Local Policing Support Team

Our Ref: LM/ARU/20/25A

Date 2nd September 2020

RE: Land to the south of Ford Lane and East of North End Road Yapton BN18 0DS

Title:
APARTMENT A
FLOOR PLAN AND ELEVATIONS

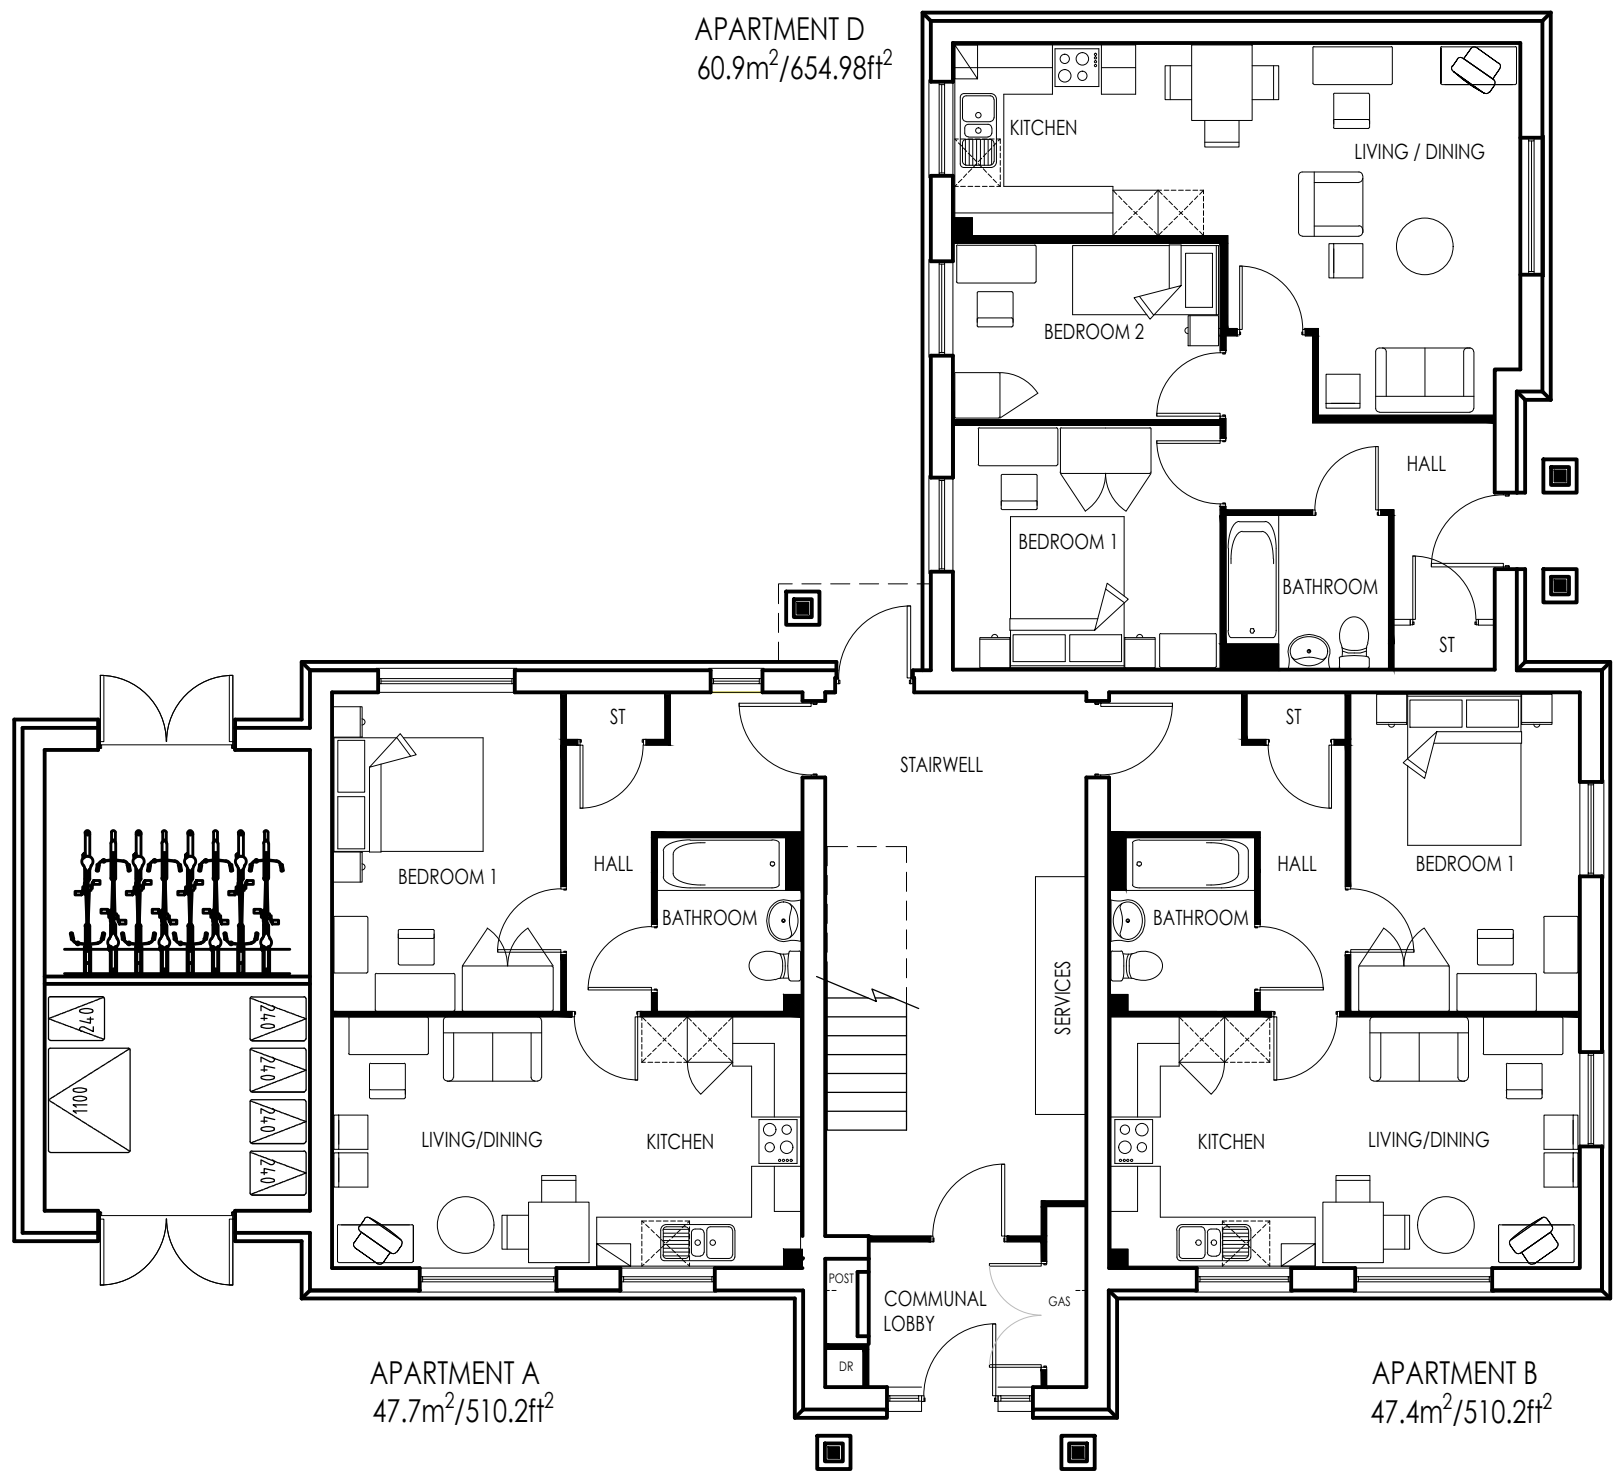
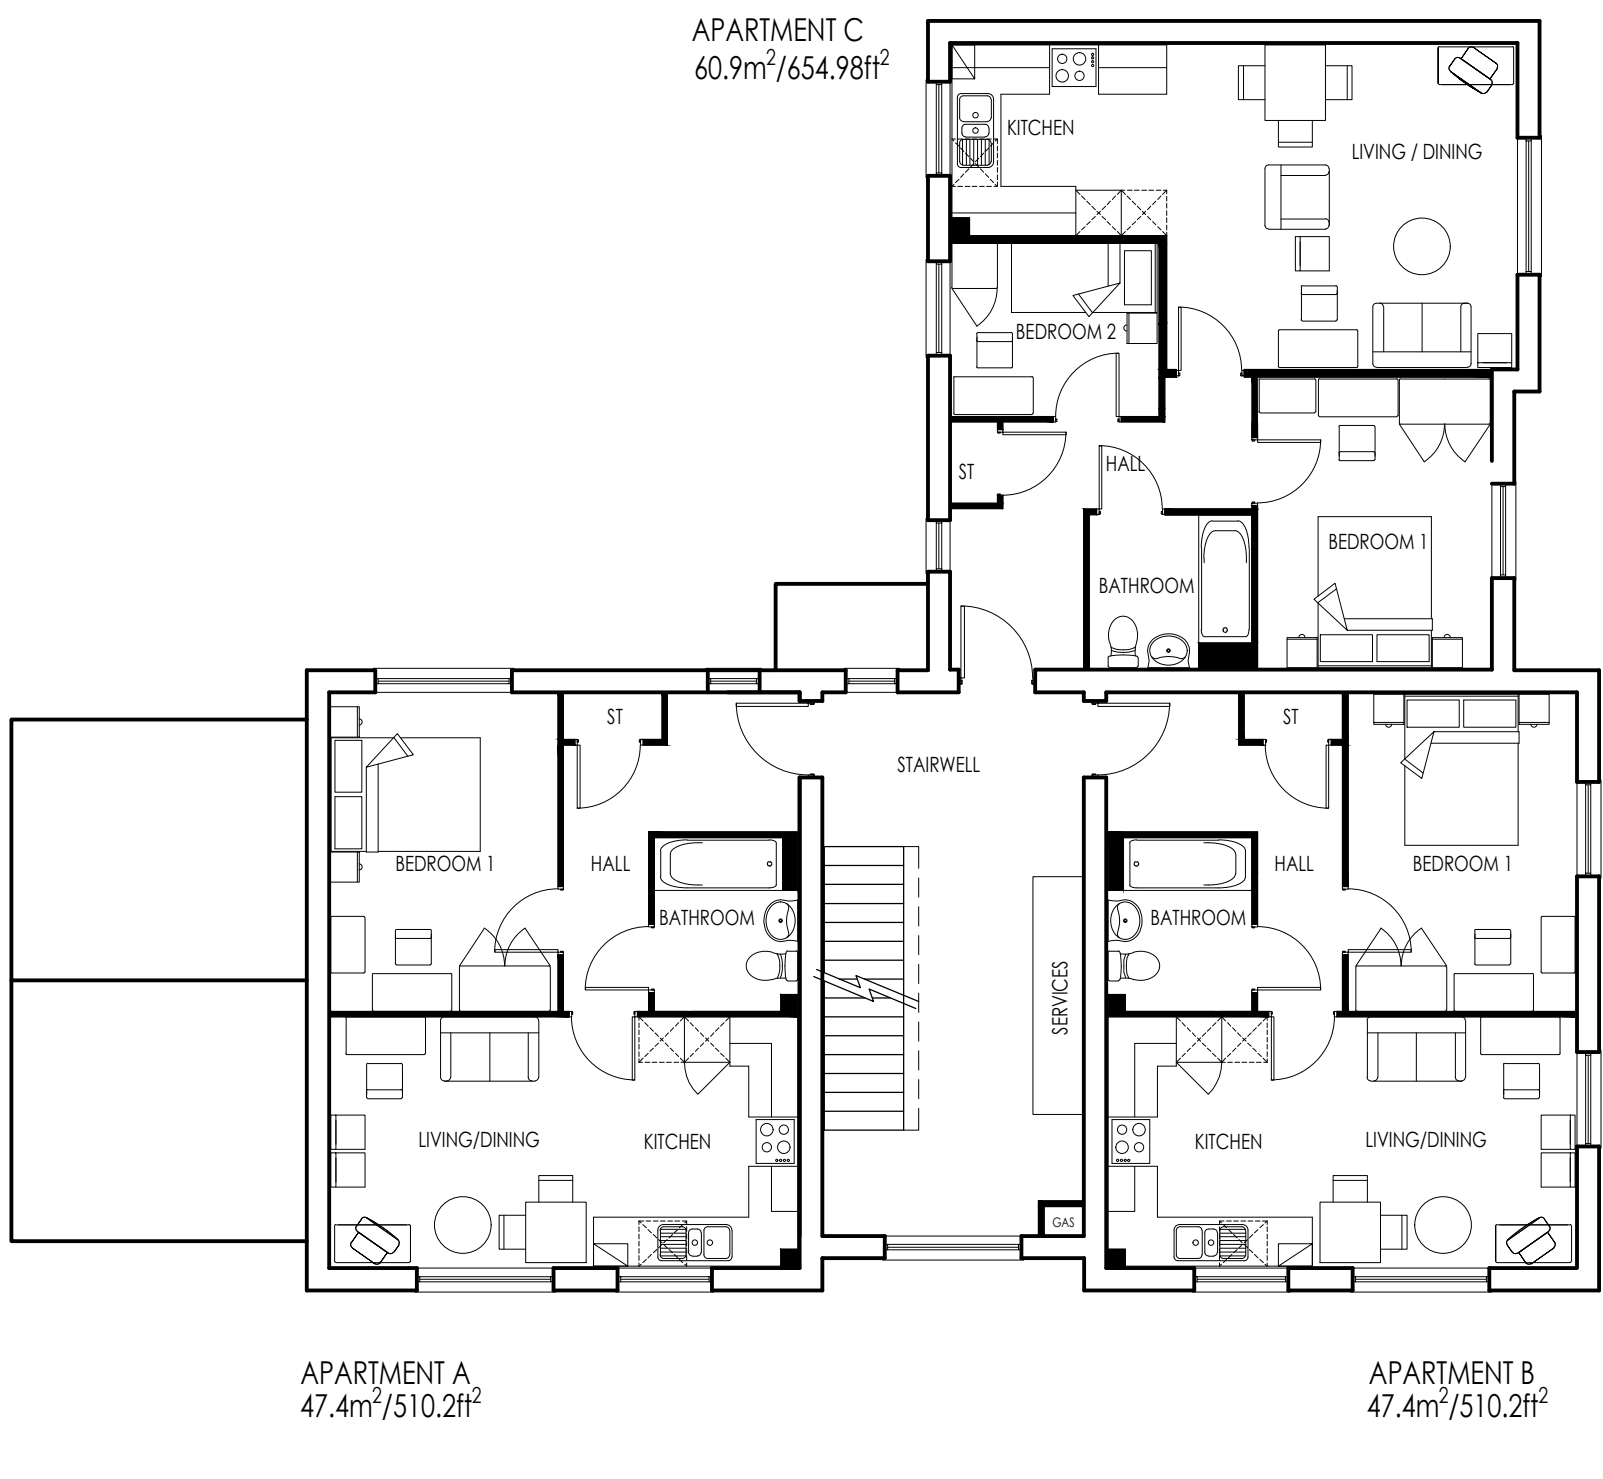
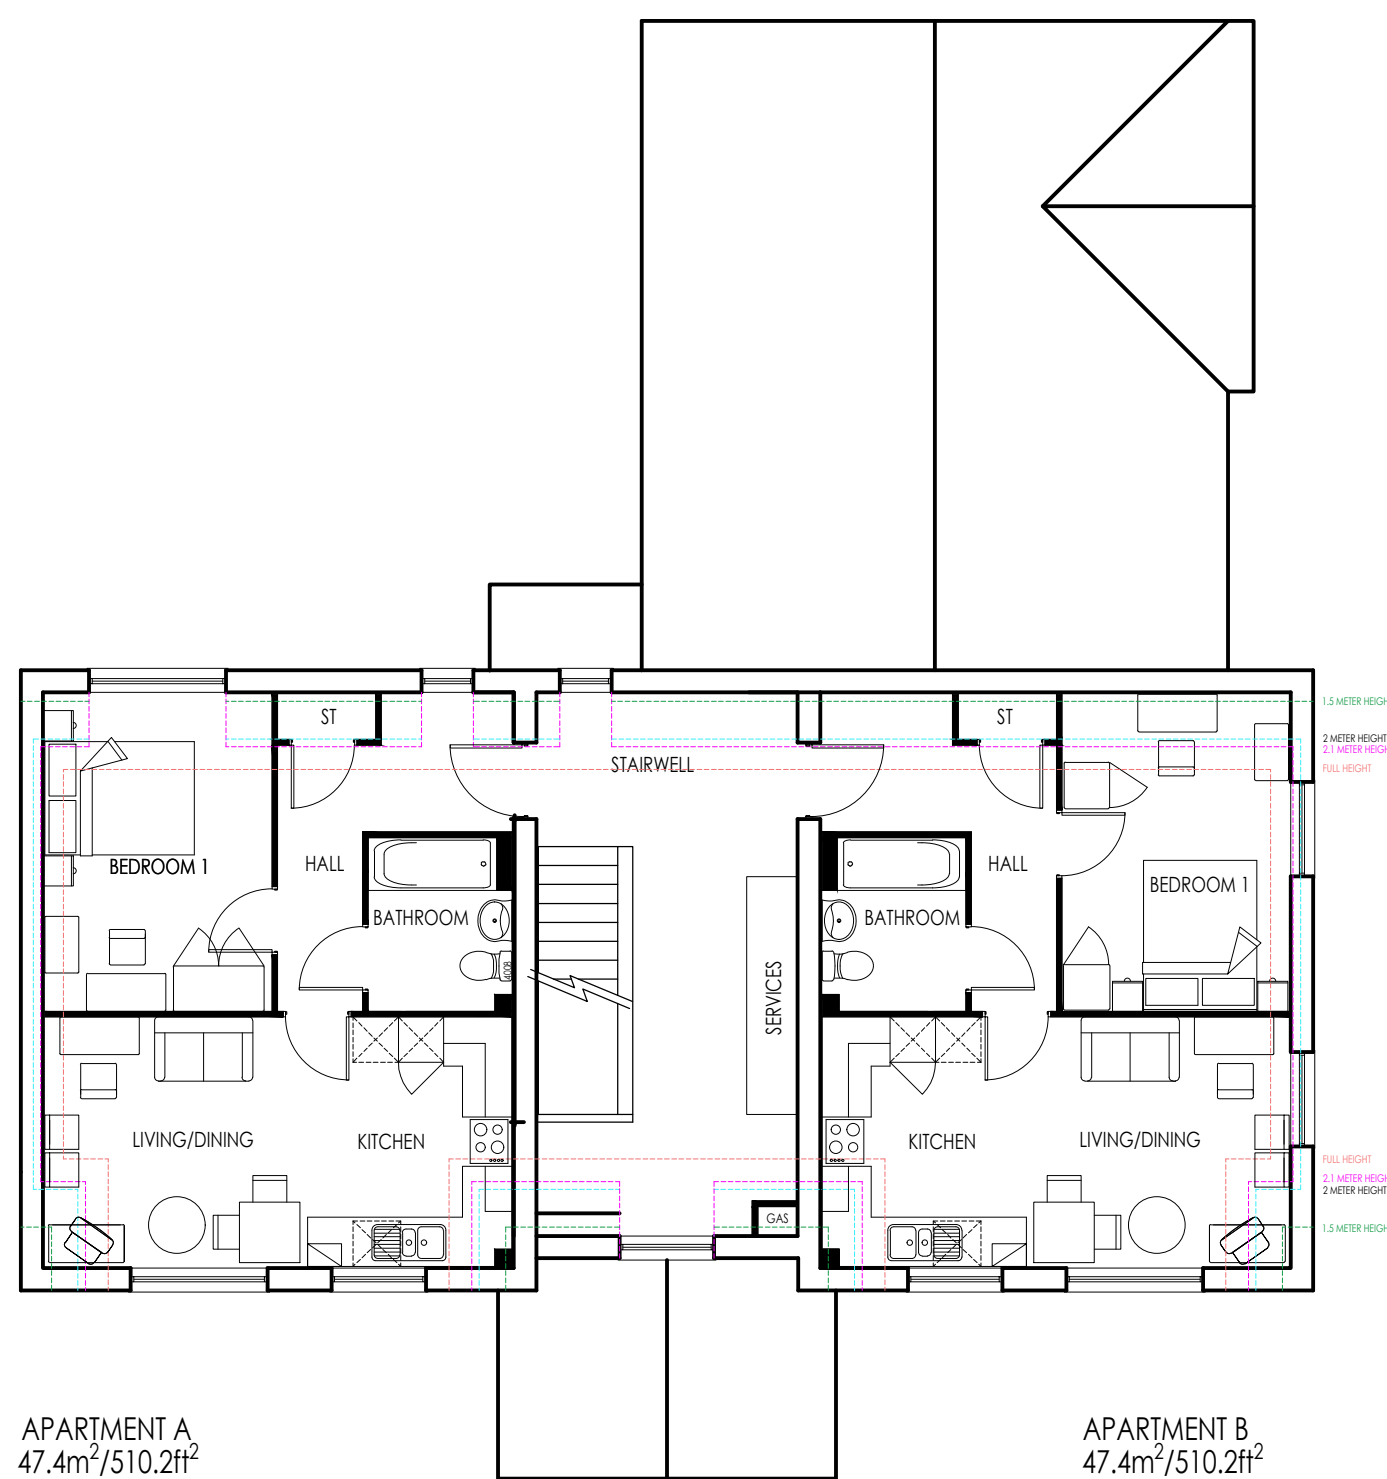
With regards to the apartments from a crime prevention perspective it will be imperative that access control is implemented into the design and layout to ensure control of entry is for authorised persons only. SBD recommends that all communal door-sets serving 5 or more dwellings or bedrooms should have visitor door entry system or access control system to enable management oversight of the security of the building i.e. to control access to the building via the management of a recognised electronic key system. It should also incorporate a remote release of the primary entrance door set and have audio visual communication (preferably colour) between the occupant and the visitor. I refer the applicant to SBD Homes Version 2 2019 Chapter 27 27:1 through to 27:28. Tradesperson or timed release mechanisms are not permitted as they have been proven to be the cause of antisocial behaviour and unlawful access to communal developments.

Additionally, I recommend the postal arrangements for the apartments is through the wall or externally mounted secure post boxes. I strongly urge the applicant not to consider letter apertures within the apartment's front doors. The absence of the letter aperture removes the opportunity for lock manipulation, fishing and arson attack and has the potential to reduce unnecessary access to the block.
